From: Geoff Gibbs [REDACTED]
Sent: 28 April 2022 19:11
To: Planning.Responses <Planning.Responses@arun.gov.uk>; katy.sharp@arun.gov.uk; Planning <Planning@arun.gov.uk>
Cc: Angmering Parish Council [REDACTED]
Subject: Re: Planning Consultation on: A/270/21/OUT

With regard to the flood risk assessment dated March 2022.

Application No: A/270/21/OUT
Registered: 4th January 2022
Site Address: Land off Arundel Road Angmering
Grid Reference: 506487 105336
Category: Plan Applicat'n
Description of Works: Hybrid application comprising:
a) Demolition of existing buildings;
b) Full planning application for the development of 160 No. dwellings with open space, landscaping and sustainable drainage systems (SuDS), and two vehicular access points from Arundel Road;
c) Outline application with all matters reserved except for up to 1,393 square metres of Class E floor-space with associated parking provision and 2.1 hectares of sports pitch land.
This site is a Departure from the Development Plan

Client: Redrow
 Job: Arundel Road Angmering
 Title: Drainage Strategy For Planning Only

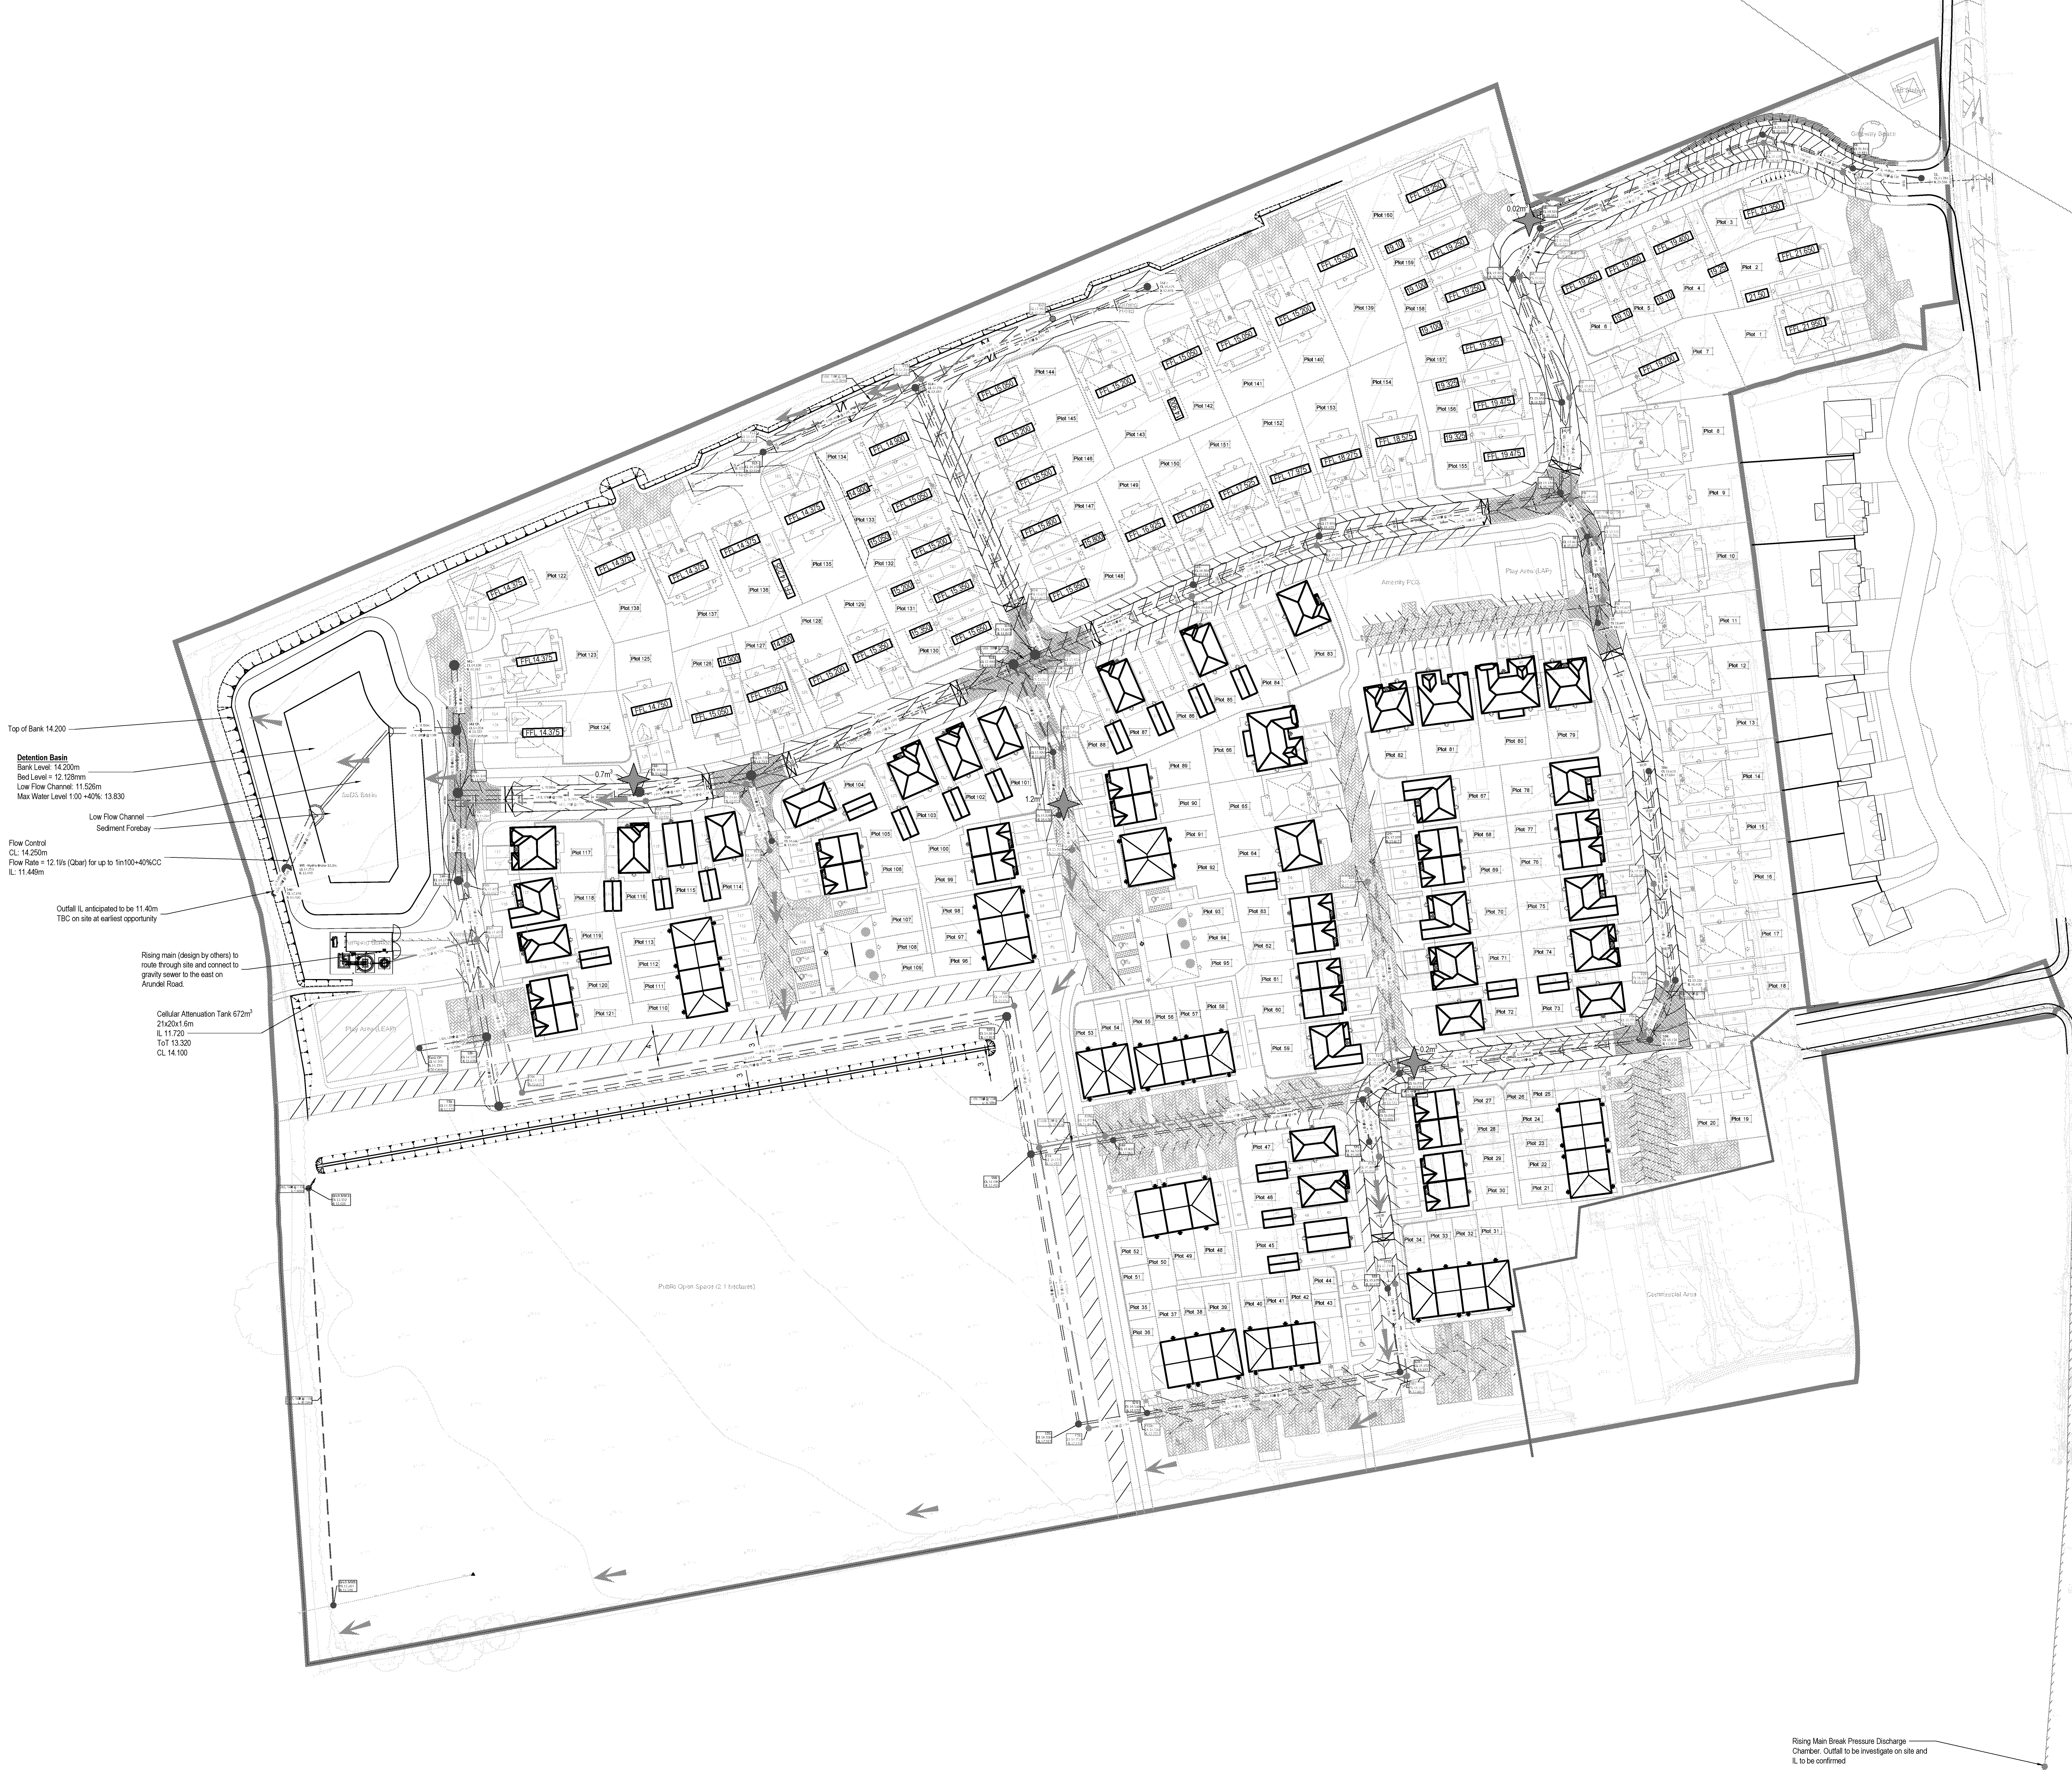
5.2.2 states that '*... infiltration drainage is deemed unfeasible at the development site*'.

5.3.2 states that '*.... the volume of runoff leaving the site cannot be reduced to greenfield / existing values ...*'

The proposal seems to concentrate on managing the flood risk to the site itself but the impact of site is just as, if not, more, important.

The FRA that accompanied the previous Outline Application stated that infiltration testing undertaken across the site showed that '*infiltration rates were not favourable*'. The infiltration tests were at discrete locations using test pits. It was not surprising to me, given the topography and geology, that the encountered groundwater levels and infiltration rates were what they were. Based on this, the earlier FRA proposed discharge to a watercourse via an attenuation basin. As explained above much guidance, including the NPPF, require the hierarchical approach to surface drainage (as, indeed, does your Council's own drainage engineer) and I believe infiltration has been

prematurely rejected without adequate investigation. Specifically I consider the earlier FRA and this latest FRA are inadequate in that they do not investigate more diffuse and widespread infiltration to replicate what happens currently to reduce the likelihood of increasing flood risk to others.

A particular danger of urbanisation is the increased volume of runoff from a development site. While attenuation should limit the flow rate of runoff, managing total volumes is much more challenging. The Black Ditch catchment drains into the tidal river Arun through a flap valve and it is possible, with potential sea level rise; this may be the reason for the Environment Agency comment. I am aware that the Environment Agency has reported on this.

The lower Black Ditch catchment will clearly become stressed if sea level rise continues as the Environment Agency alluded to in responding to an earlier outline planning application for this site. I believe more work is necessary to achieve drainage of the site that more closely replicates what happens now and does not adversely impact off site.
